A46 Newark Bypass

**Statement of Common Ground
with Nottinghamshire County Council**

February 2025

Statement of Common Ground with Nottinghamshire County Council

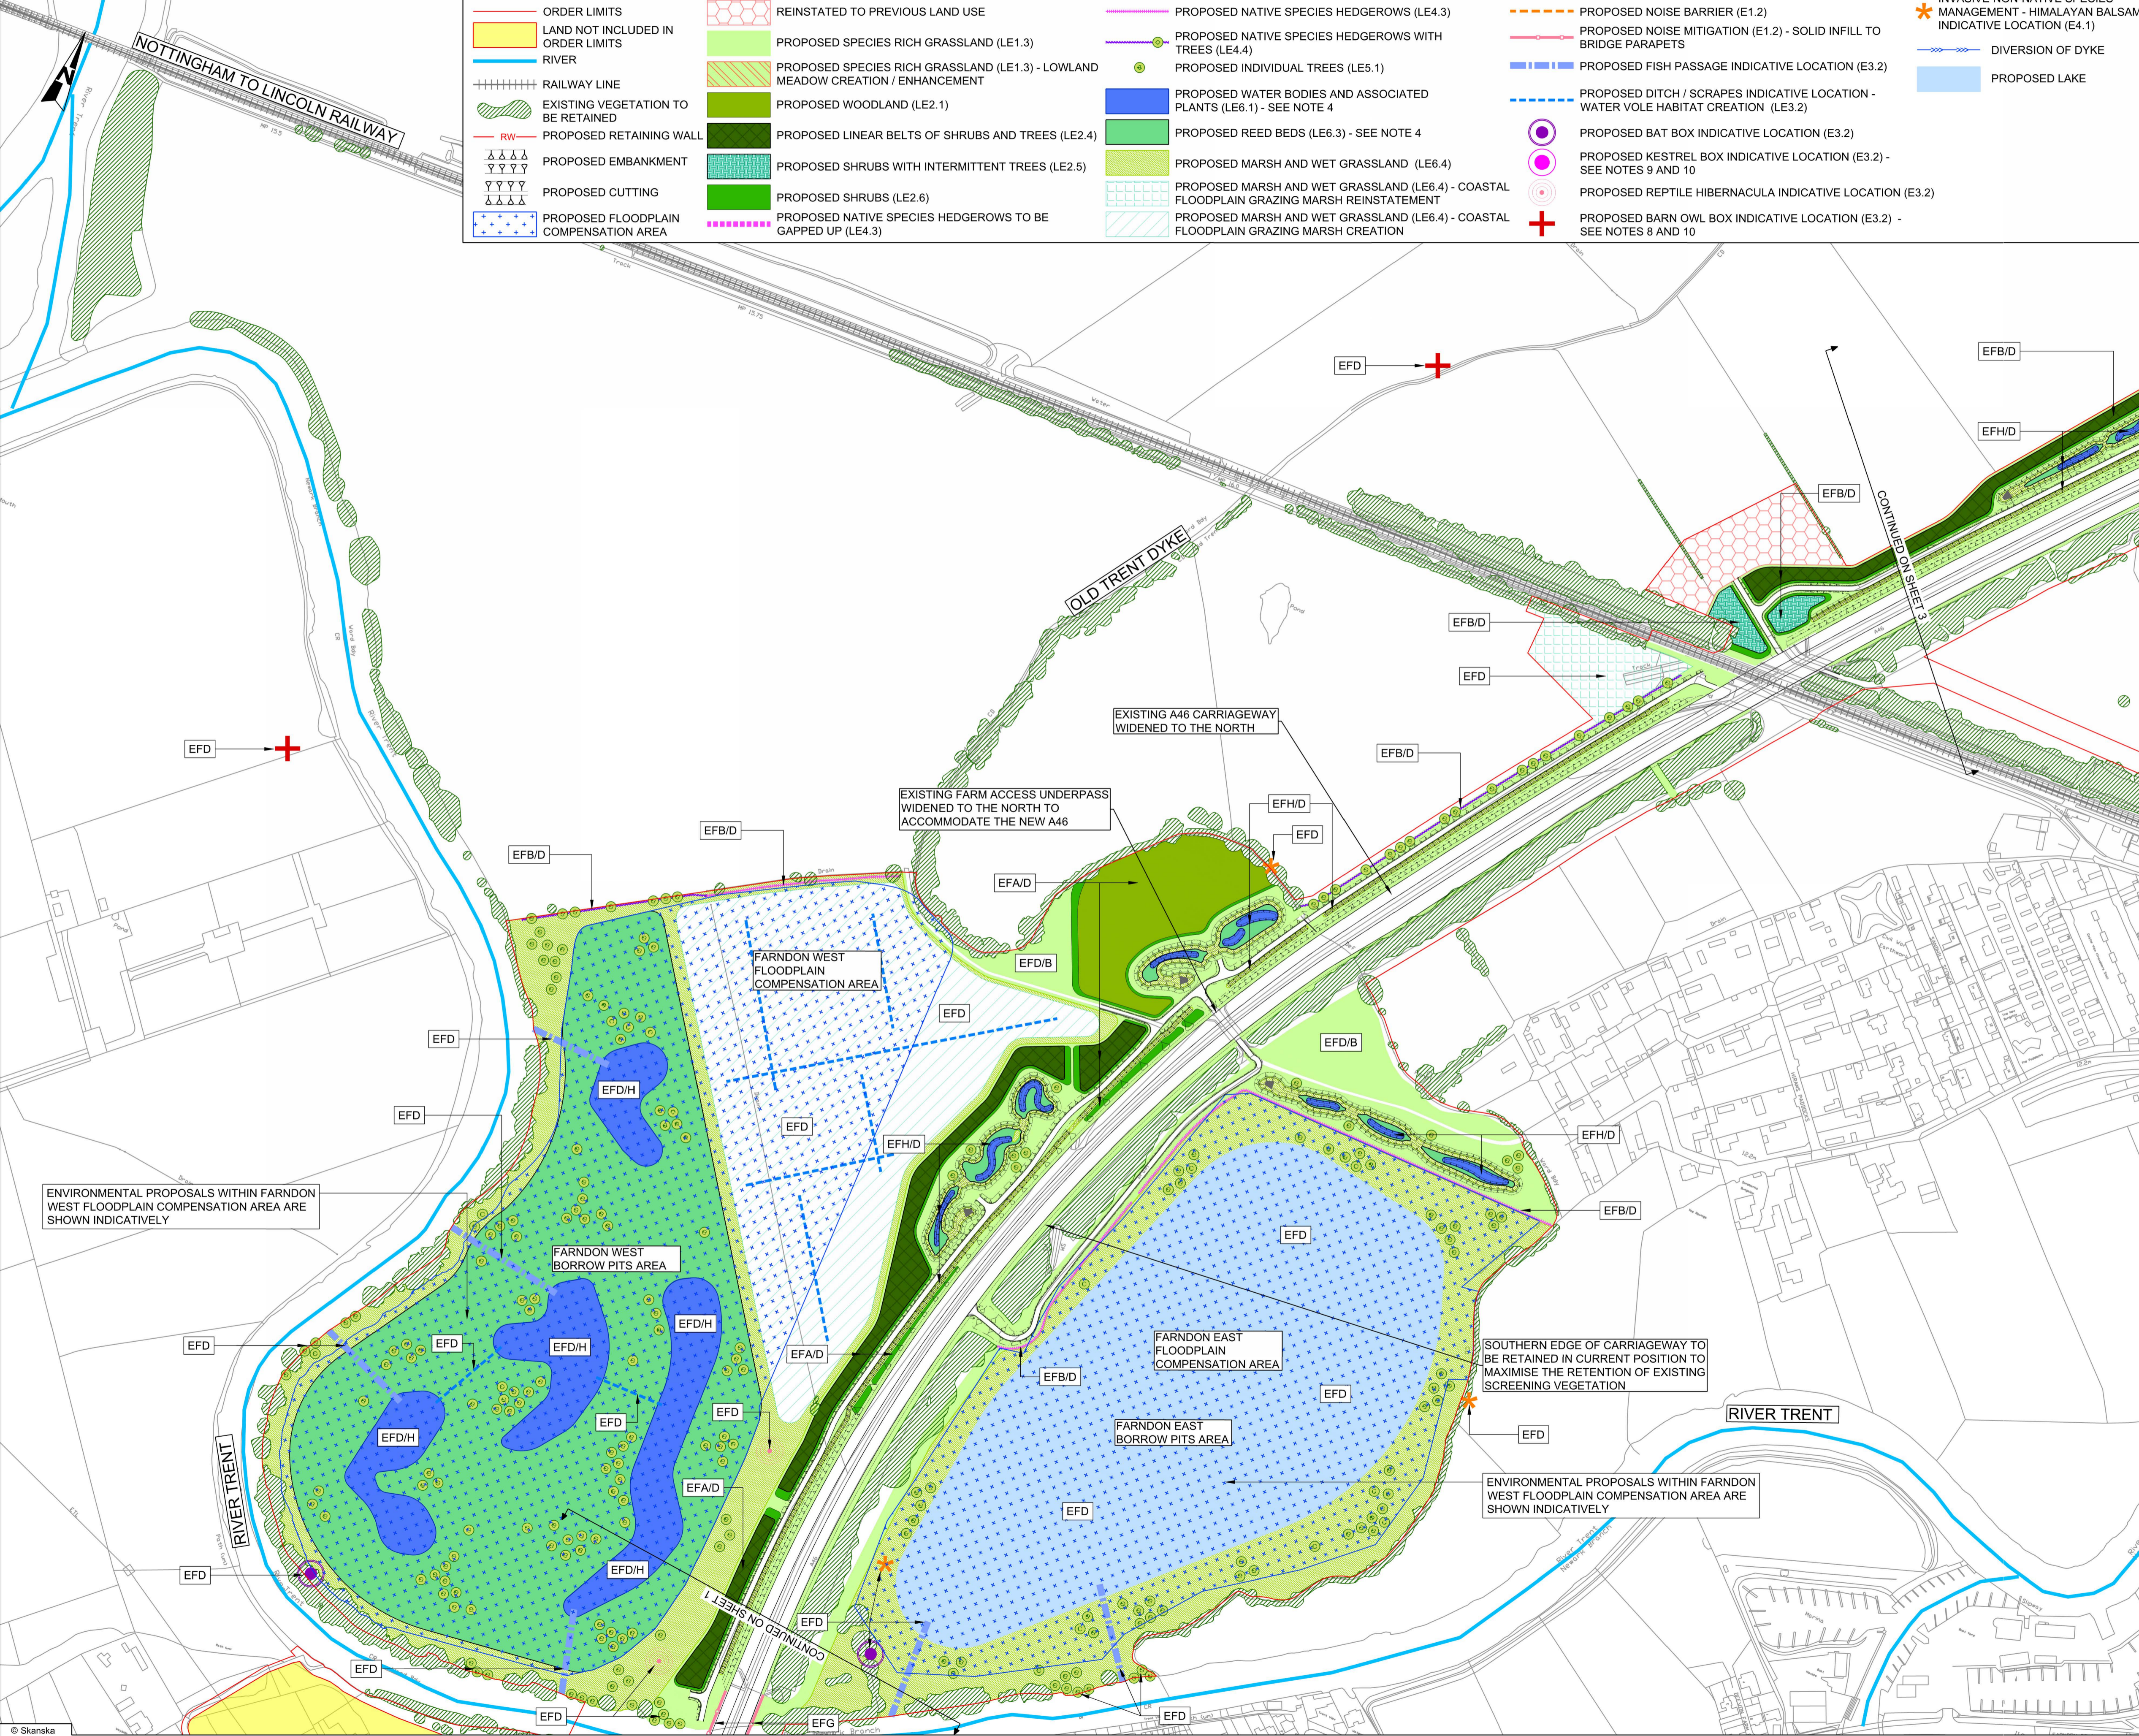
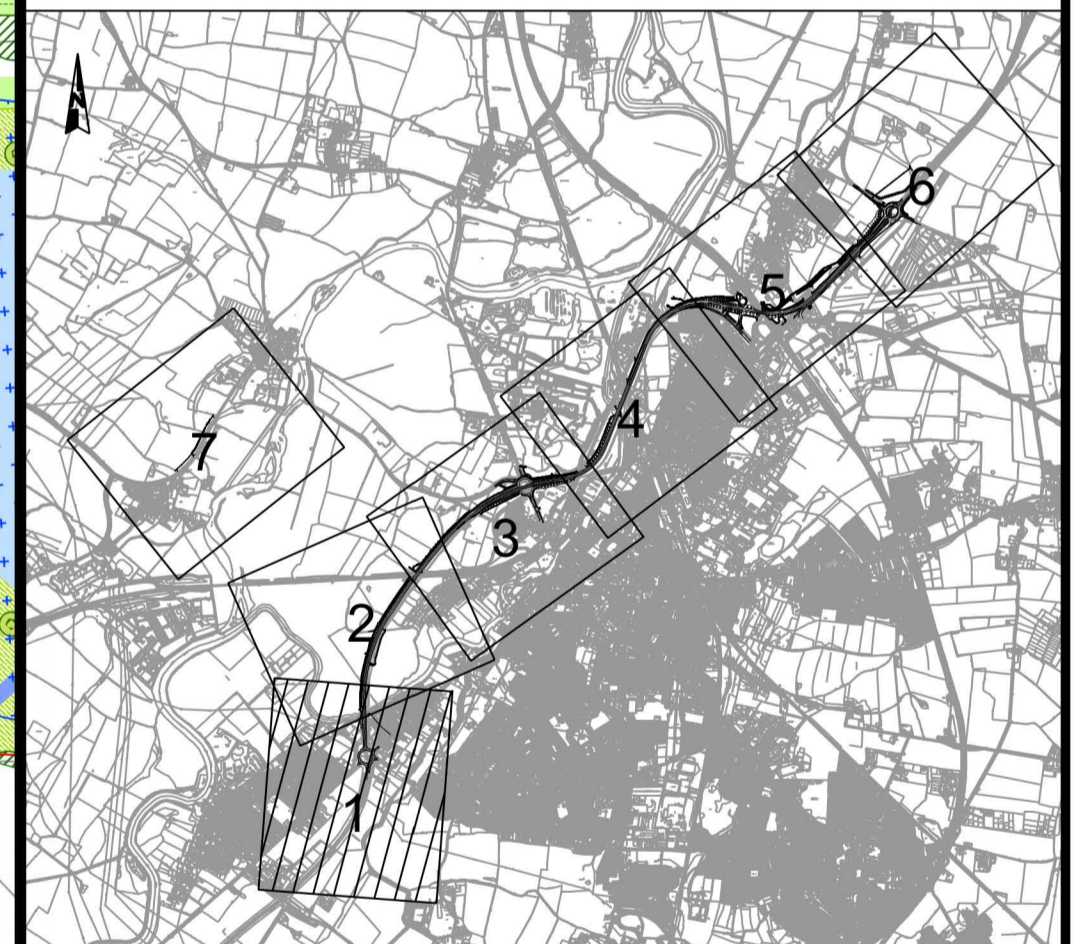
5.	PRoW		Farndon A46 roundabout The plans indicate that the Farndon Underpass will remain open throughout the works which is good. As you are aware the land adjacent to Crees Lane is currently used by members of the public as a walking route, we are also aware that National Highways are planning to use this as a compound. We would support the opportunity to create a public footpath at this location to link the underpass with Footpath No.5 and Bridleway No.2. Farndon A46 roundabout - the land which is set out for the works compound adjacent to Crees Lane has a number of unrecorded desire lines through it. It would be advantageous to see these formally recorded and set out following completion of the Scheme.	Following feedback received as part of the statutory consultation, the temporary diversion of bridleway BW2 was changed, and an alternative route was presented as part of the targeted consultation on the Scheme between 14 March and 16 April 2023. Following further feedback received as part of the targeted consultation the temporary diversion of the bridleway will be only for use by equestrians. Pedestrians and cyclists will utilise the existing footpath FP5 from the River Trent to gain access to the route adjacent to Crees Lane shown within the Order Limits. The unrecorded desire lines are on a piece of land that has been identified for temporary use as part of Scheme, any activity to formally record these desire lines as Public Rights of Way would need to be undertaken by stakeholders, including NCC, outside of the Scheme.	Agreed	04/11/2024
